Our Ref: R/189/18/PL
Your Ref:

Town & Country Planning Act 1990 (as amended)
Town and Country Planning (Development Management Procedure) (England) Order 2015
Application for Planning Permission

Development Single storey side extension

Location 1 Artex Avenue Rustington

Metres
Apple Pips
1 Artex Avenue
Rustington
Block Plan 1:500
A4 Paper

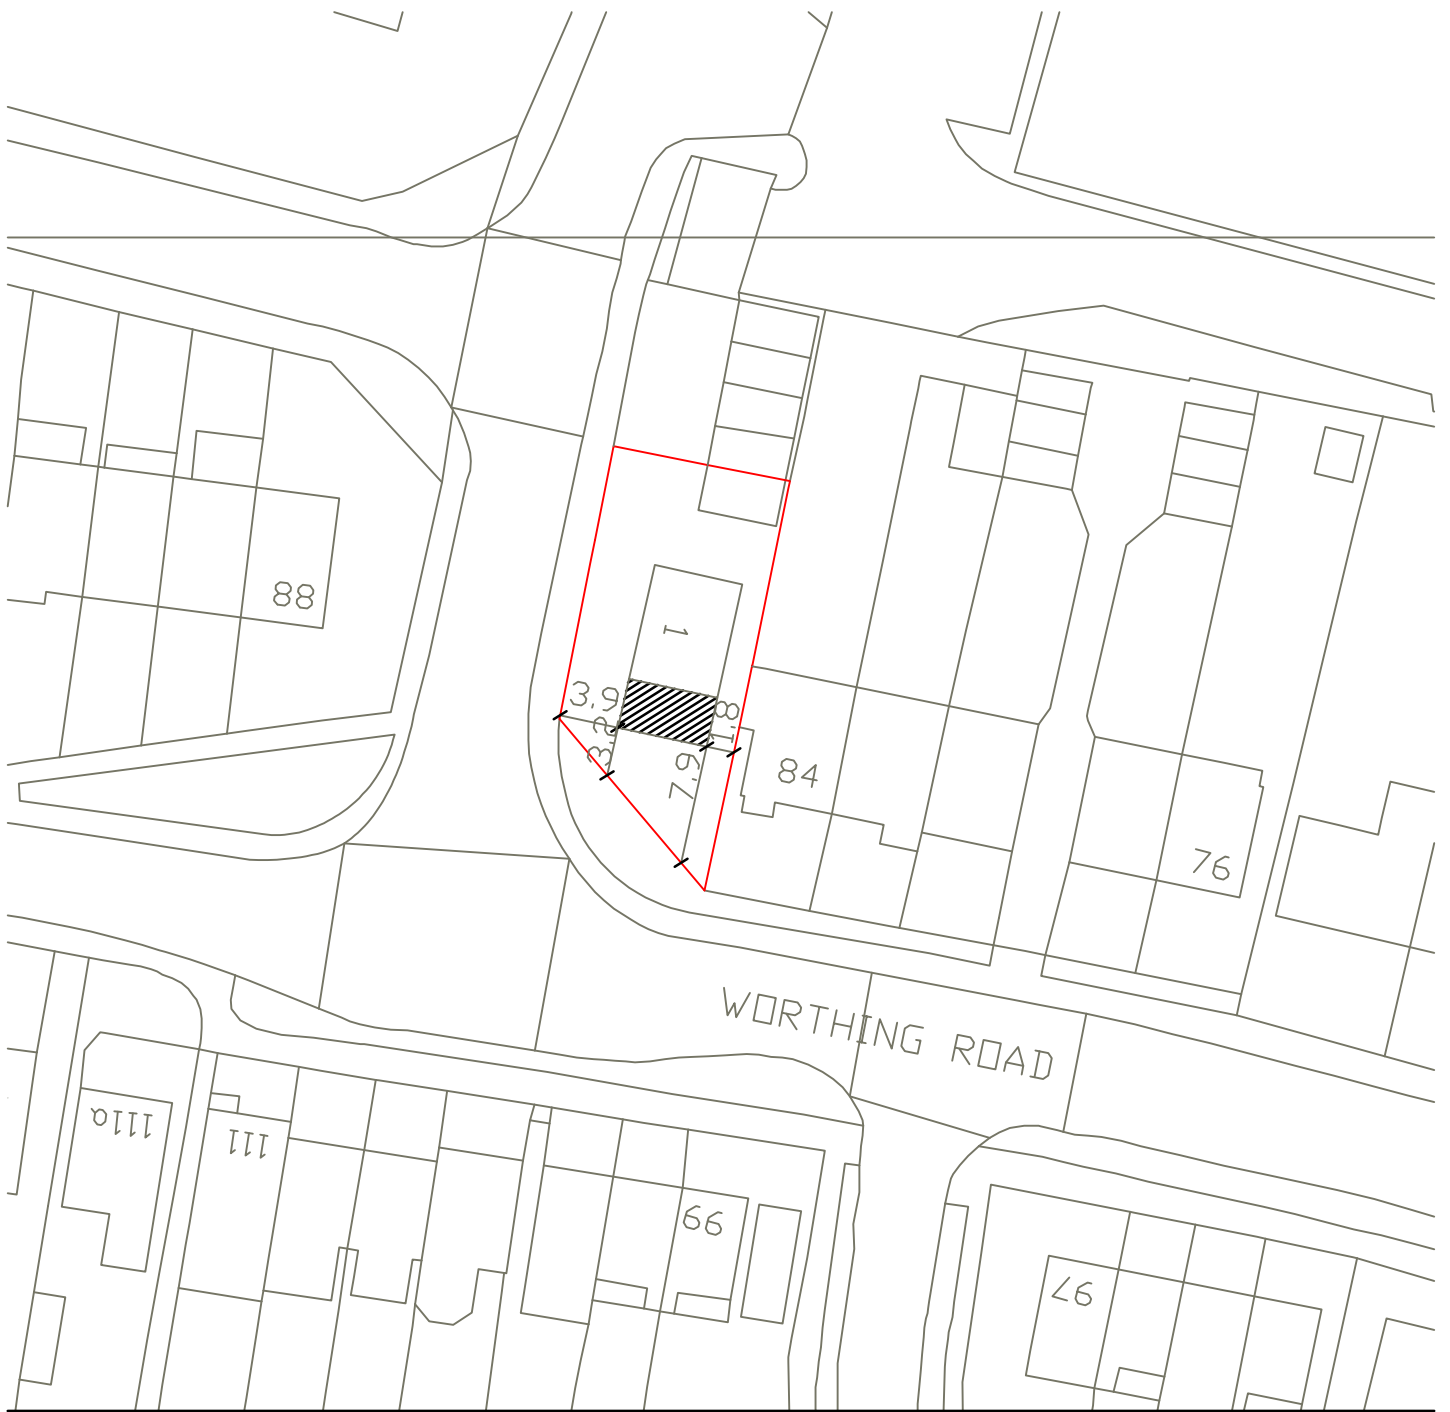
Block Plan Amend

Please provide measurements from the proposal to the site boundaries.
